REF: GRADING AND DRAINAGE PLAN FOR PROPOSED ADDITION TO REPAIR SHOP
(J14-D9) RECEIVED JUNE 6, 1984

Re: Industrial Electric Equipment Service Addition - Dated 11/12/82
501 Kinley Avenue SE (File No. J14-D9)

RE: Industrial Electric Equipment Service Drainage Report Addendum
Dated September 3, 1981 (File No. J-14-D 9)

Re: INDUSTRIAL ELECTRIC EQUIPMENT SERVICE IN ALBUQUERQUE, NEW MEXICO.

TYPICAL SECTION
PONDING AREA

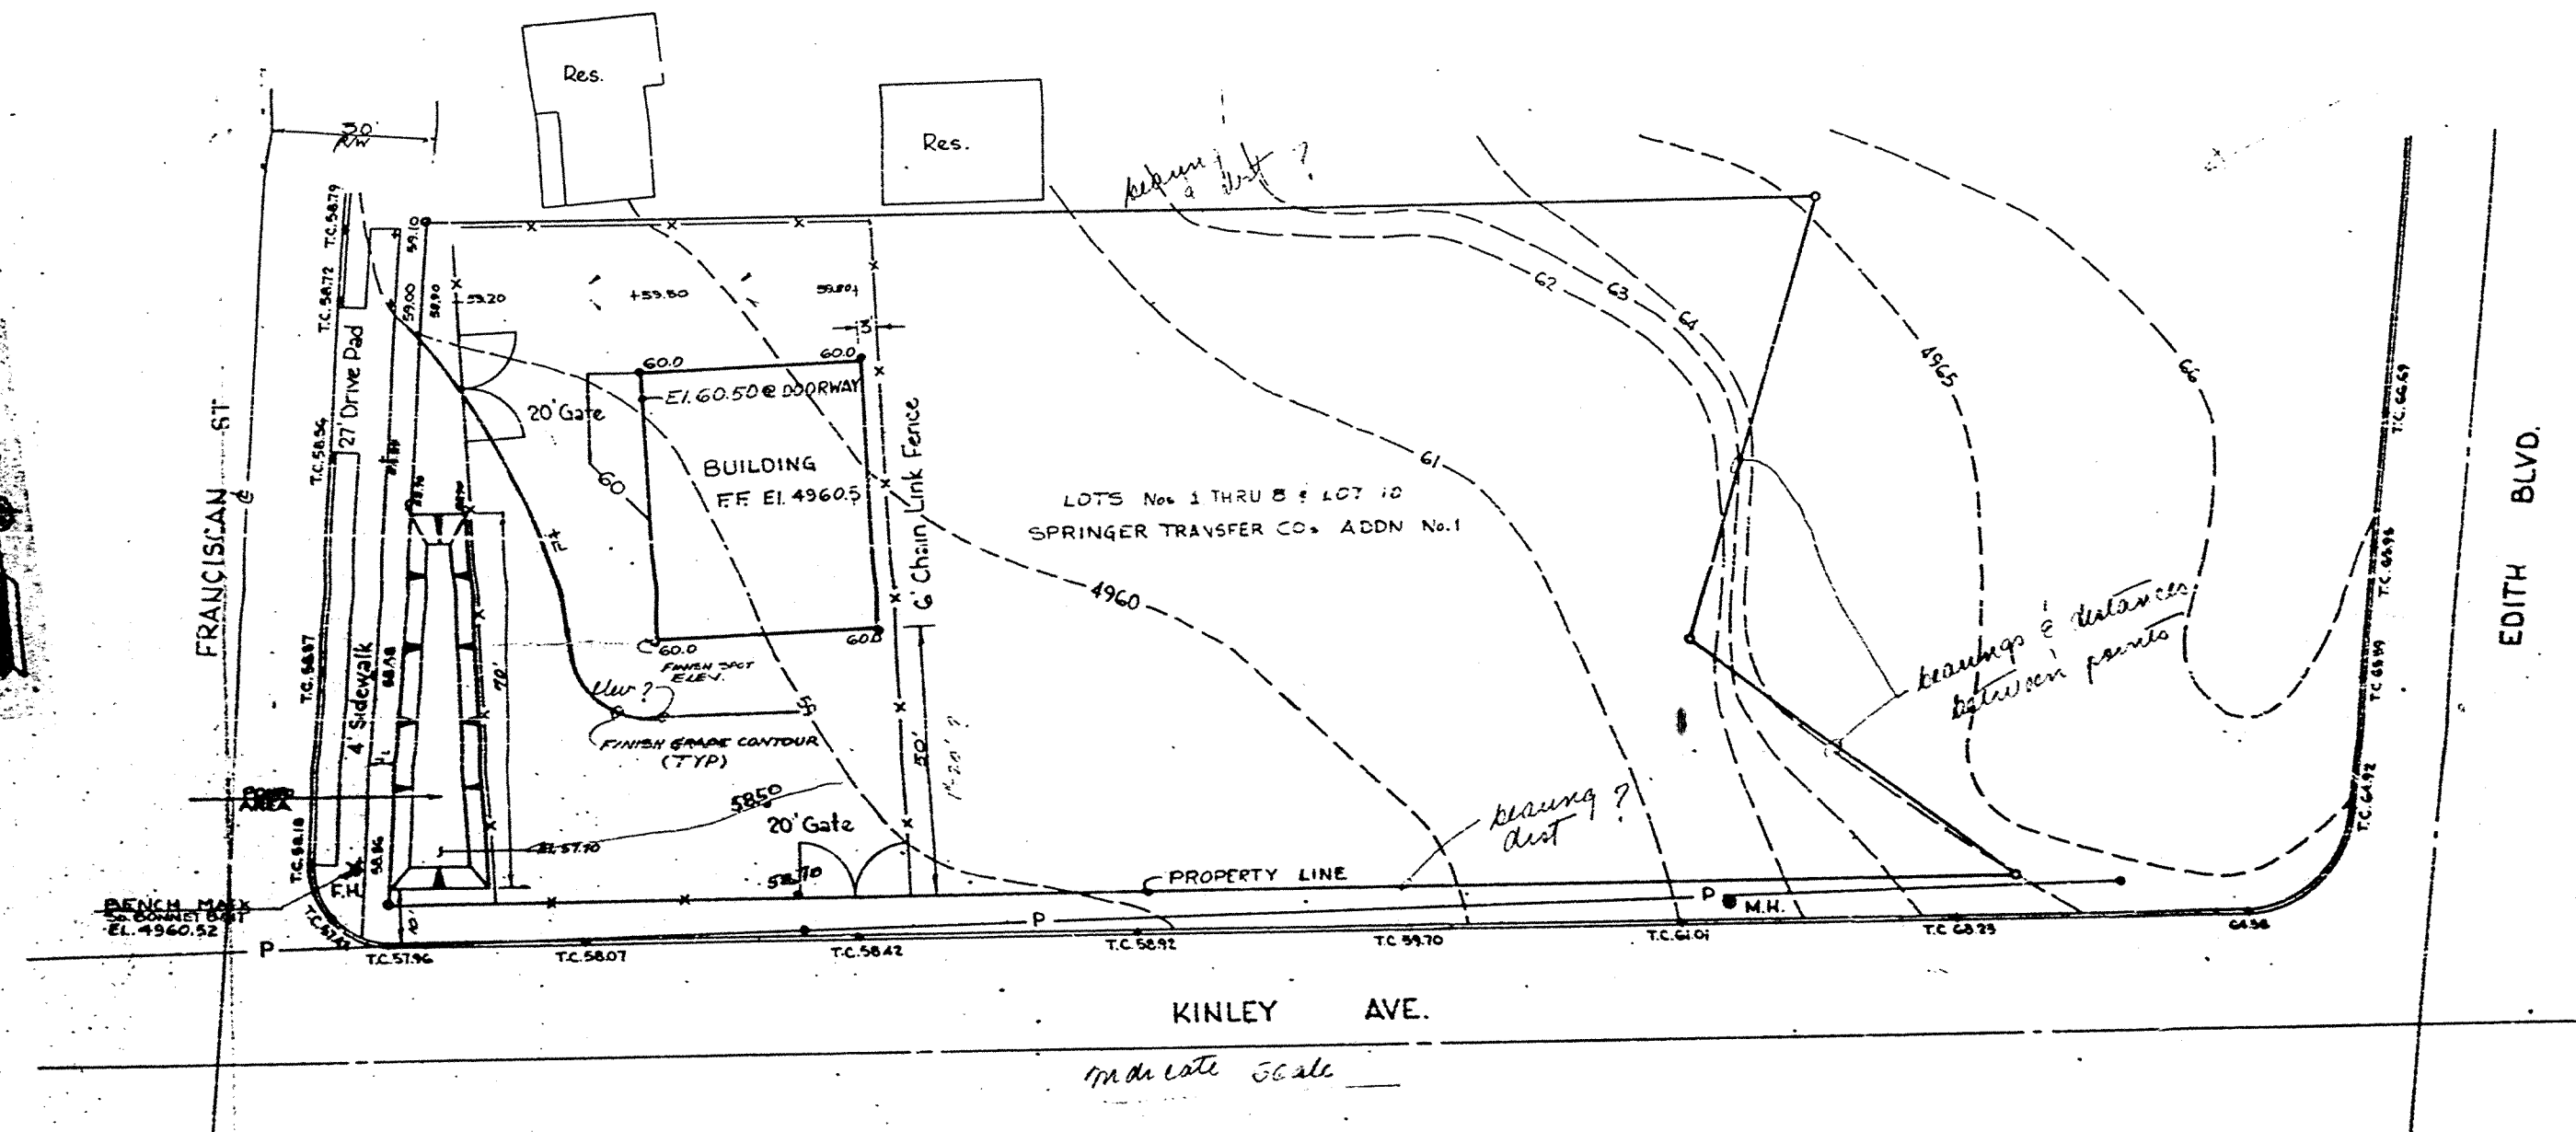
The proposed addition for the referenced site does not address how the 4 foot change in grade along the north property line will be accomplished to maintain the integrity of the existing grade on the abutting property to the north. Also, please provide us with a typical detail or details of the proposed swale along the west side of the proposed addition.

✓ Item 15 B1: Unable to verify pond volumes indicated, please dimension and provide elevations on the cross-sections.

✓ Item 15 B3: Indicate with spot elevations the overflow point for each pond.

PLAT NO. 1
INDUSTRIAL ELECTRIC EQUIPMENT SERVICE

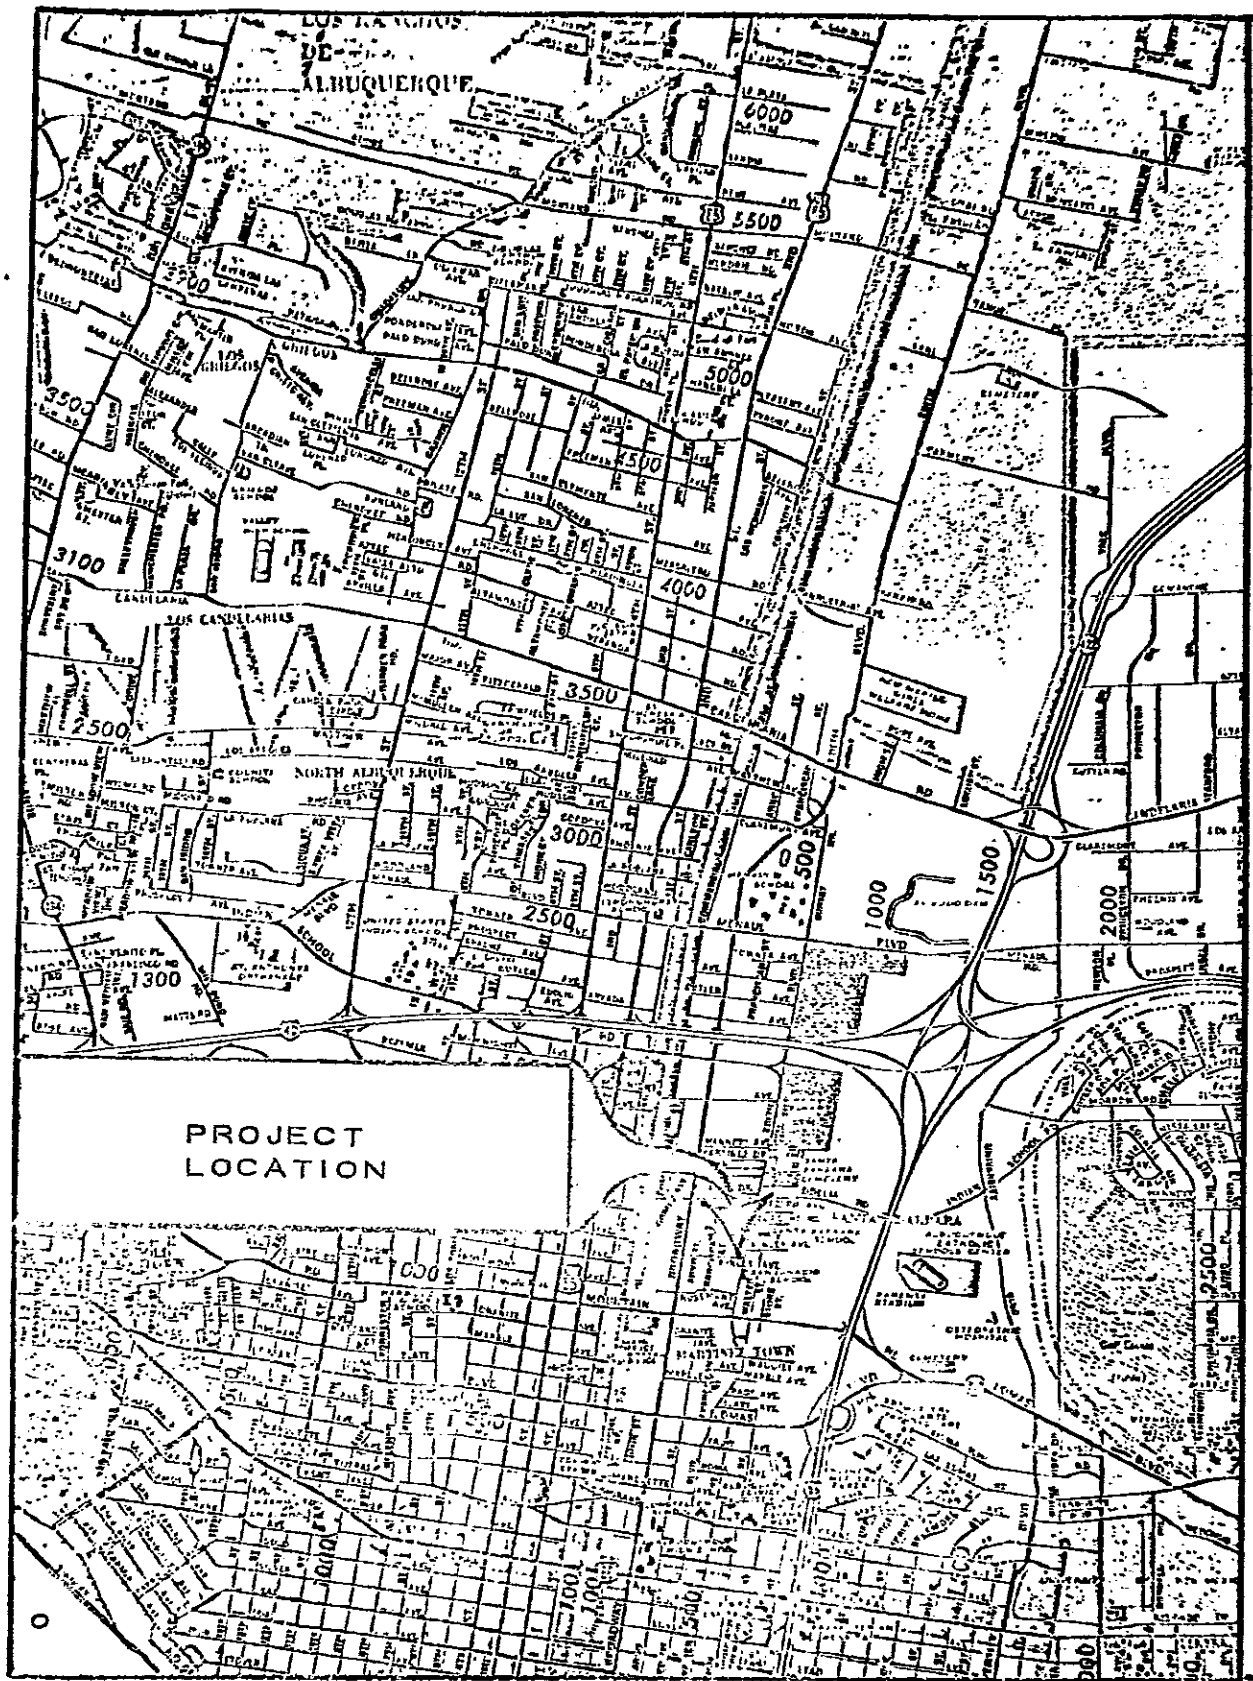
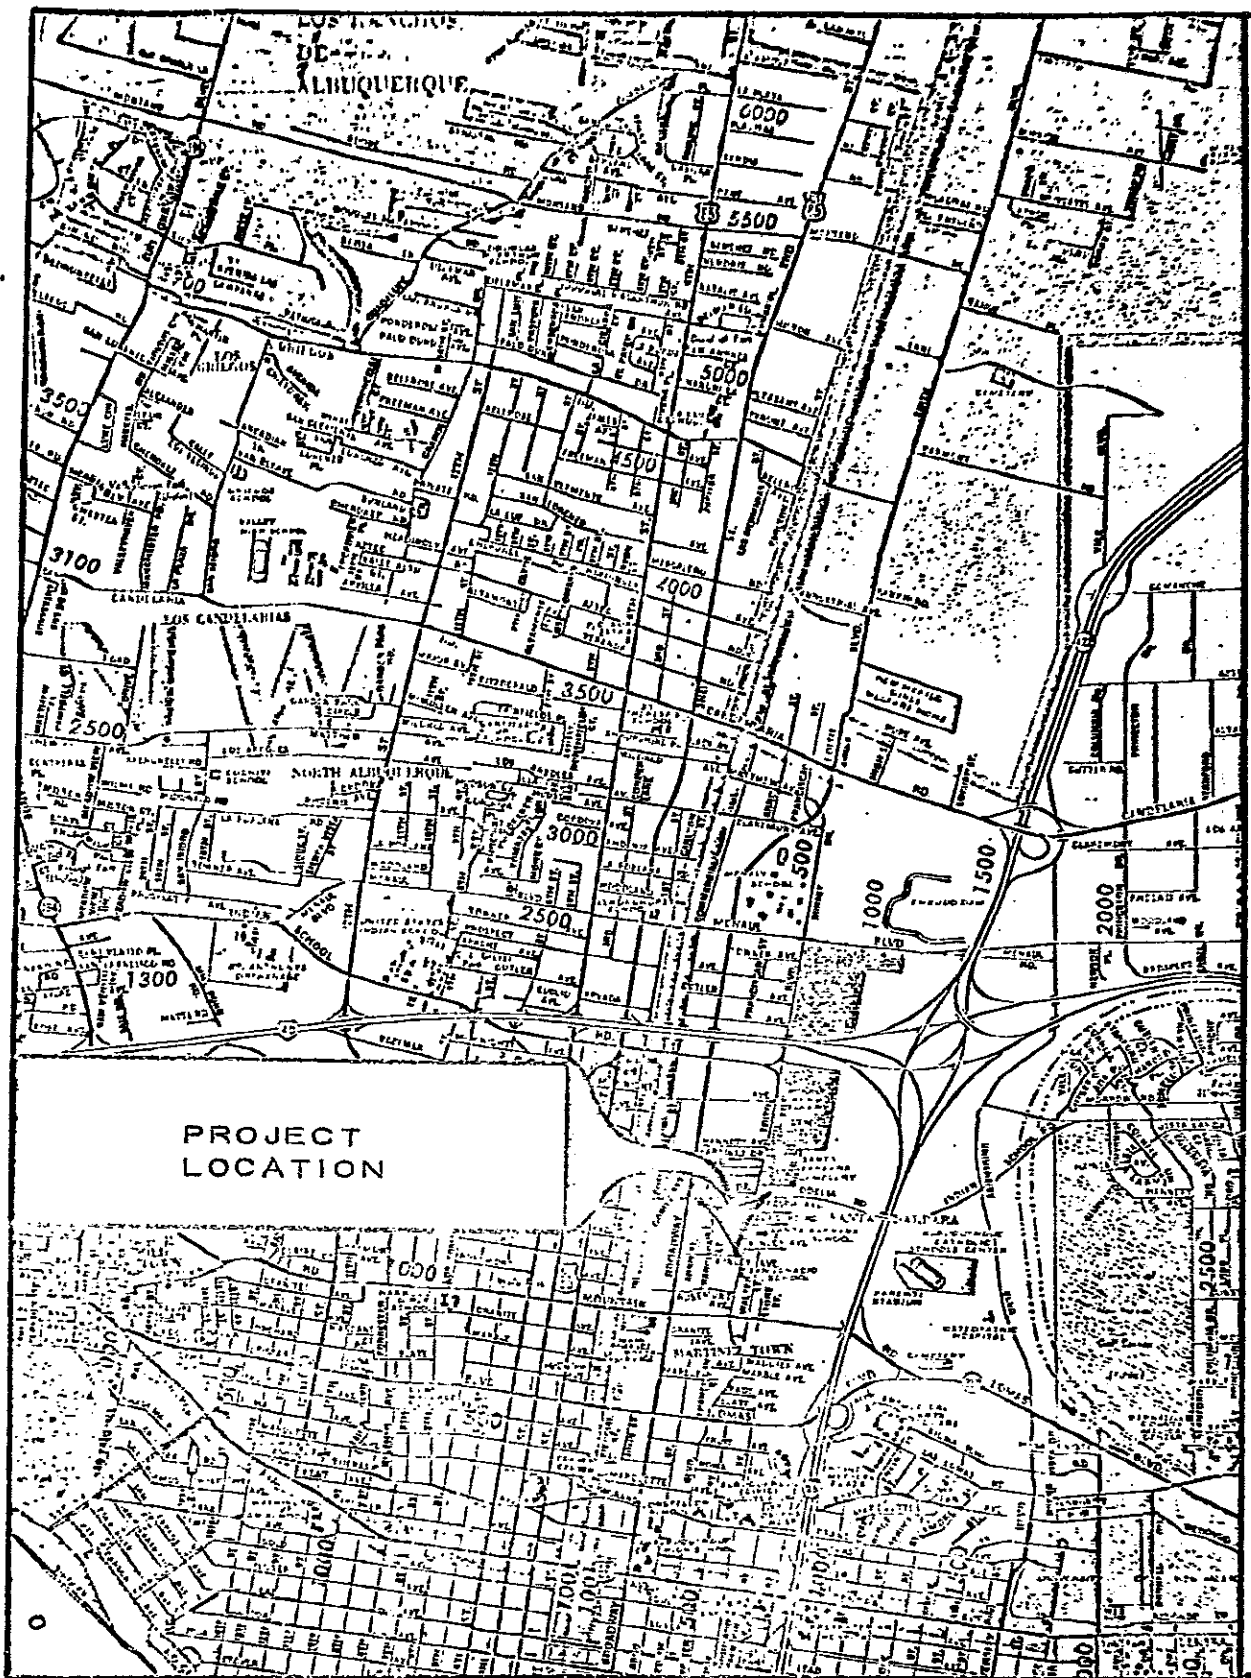
2. I notice that the ponding area provided appears located in part outside the property line (within Franciscan Street right-of-way?). If so, the pond would not be acceptable: ponding requirement must be located within the property without encroachment of public right-of-way (which is requested and dedicated for other public purposes).
3. The grading on the site as indicated does not insure the routing of the runoff through the pond. A good portion of the runoff can drain into the streets.

DRAINAGE PLAN - SHEET 1 OF 1
REPAIR SHOP ADDITION-INDUSTRIAL ELECTRIC
501 KILLEY AVE., NE. D.L. 6-5-84

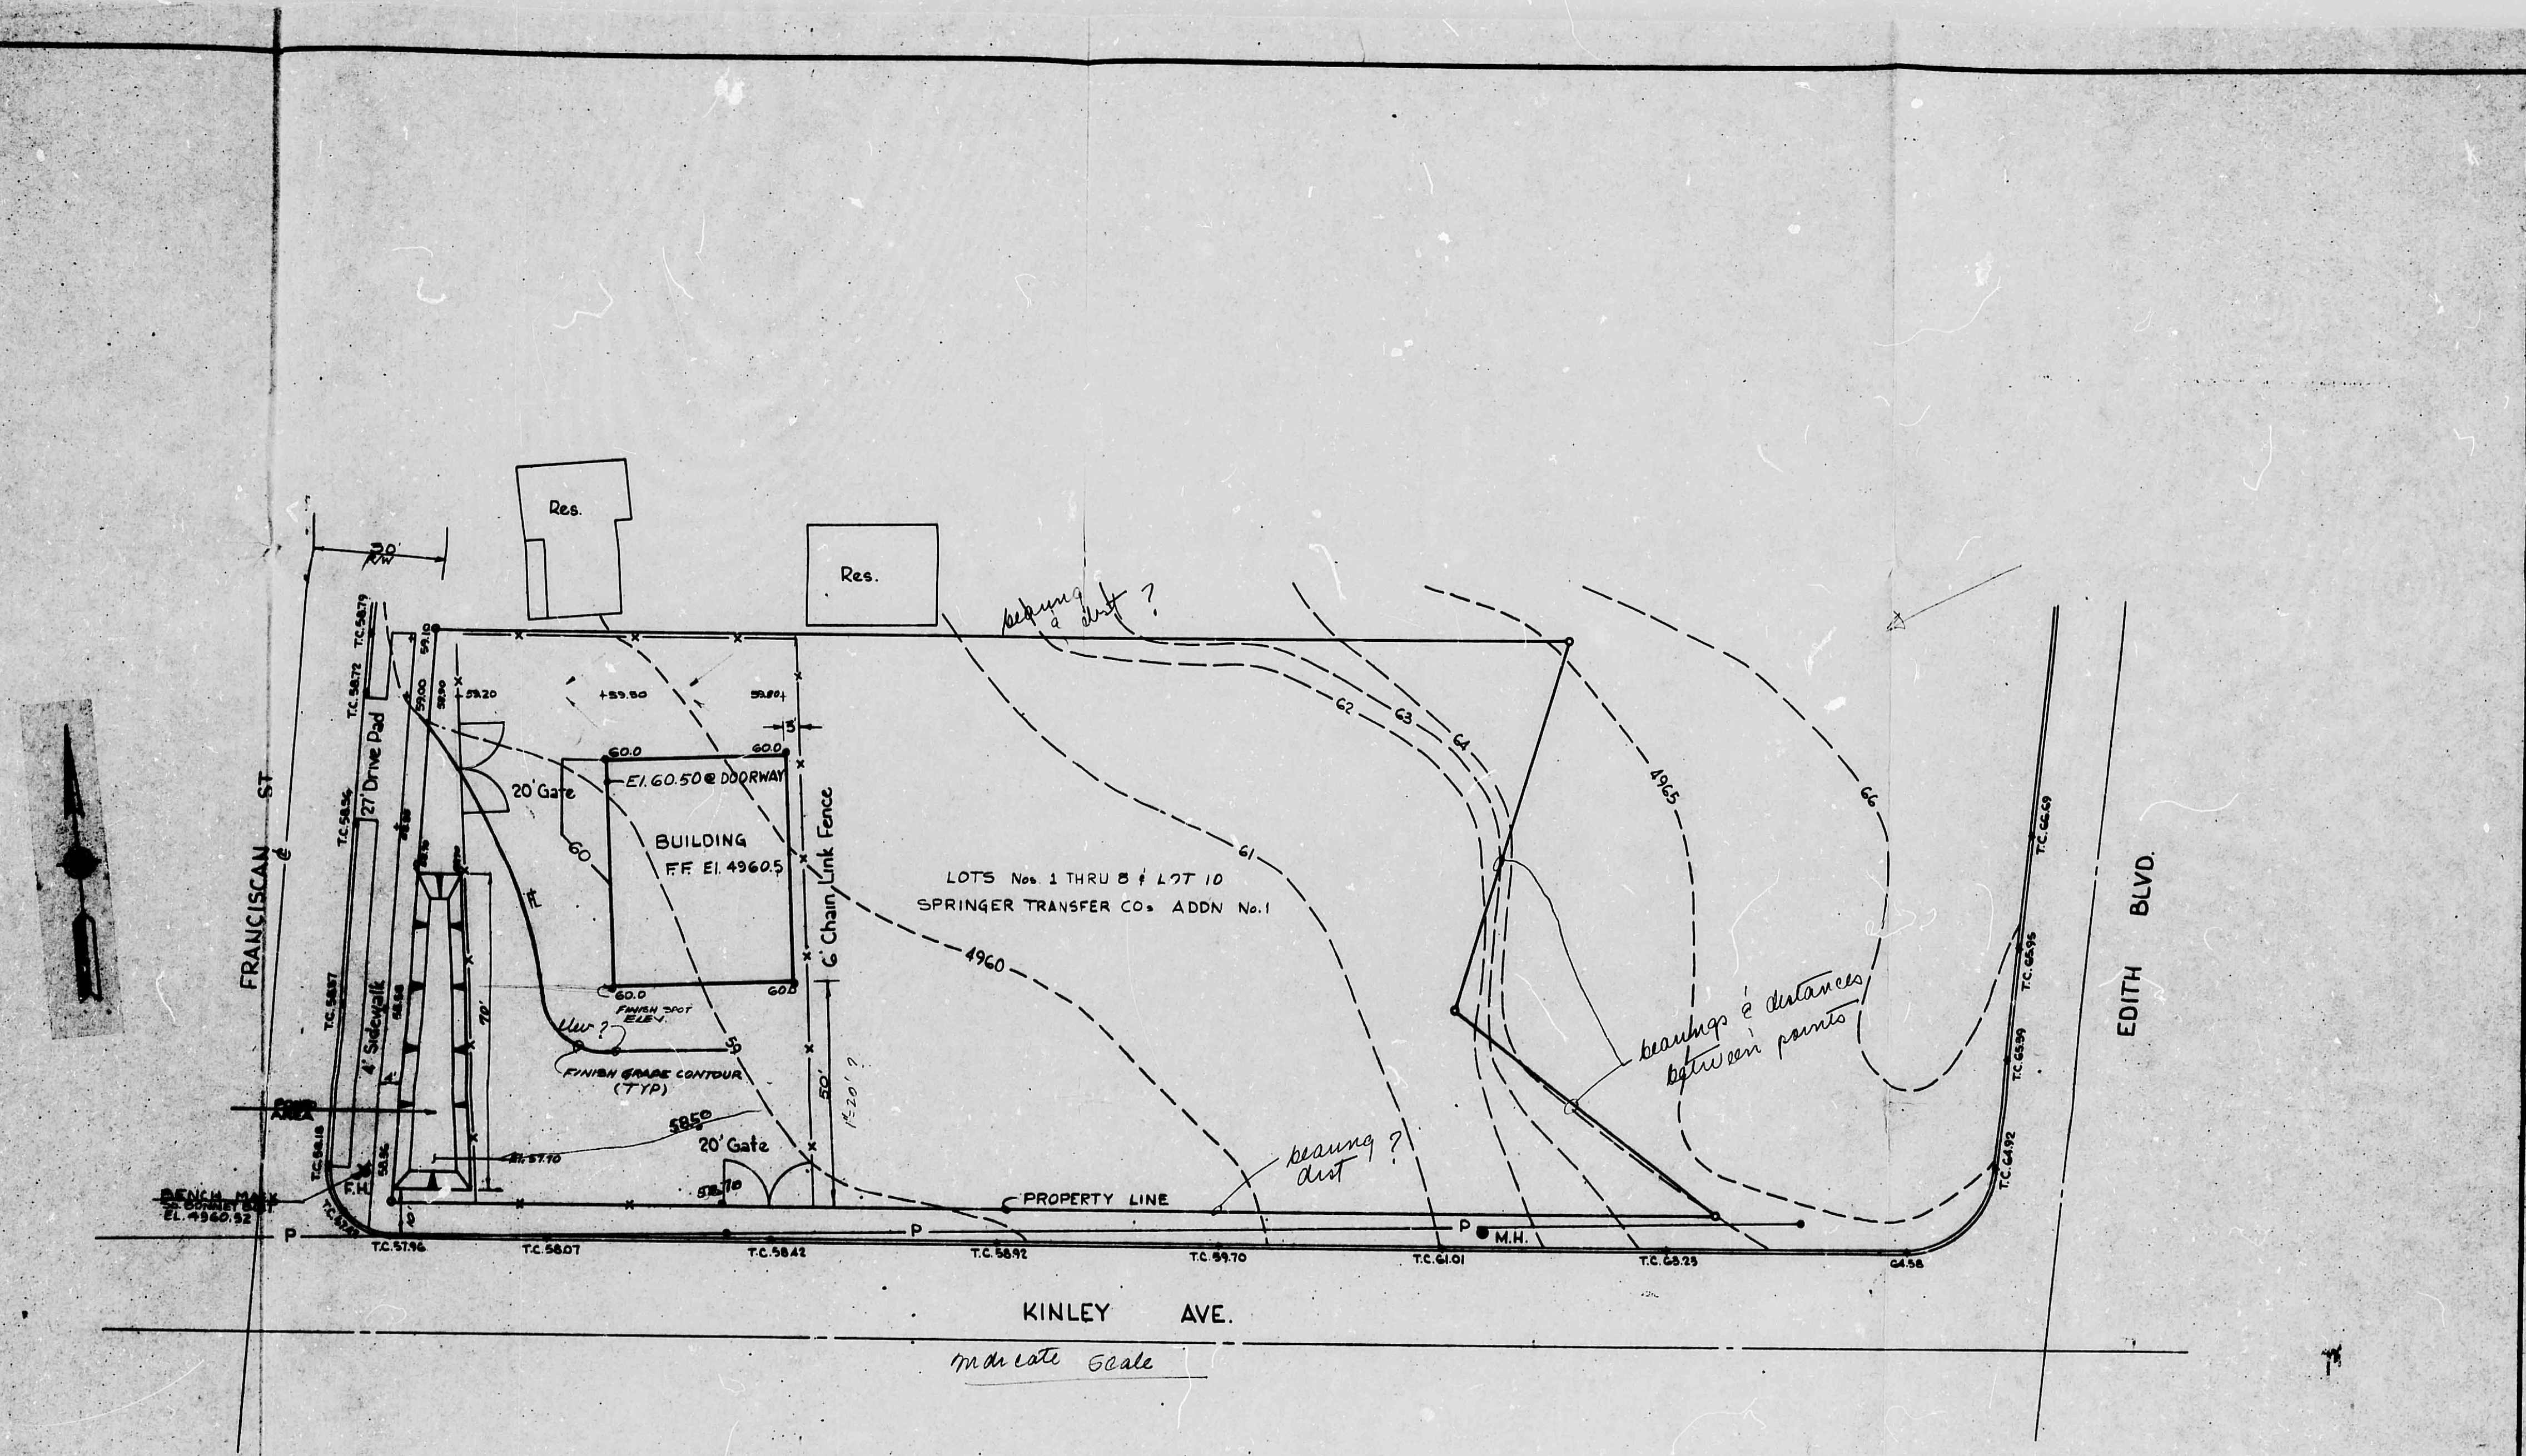
The above referenced plan, dated June 5, 1984, is approved.
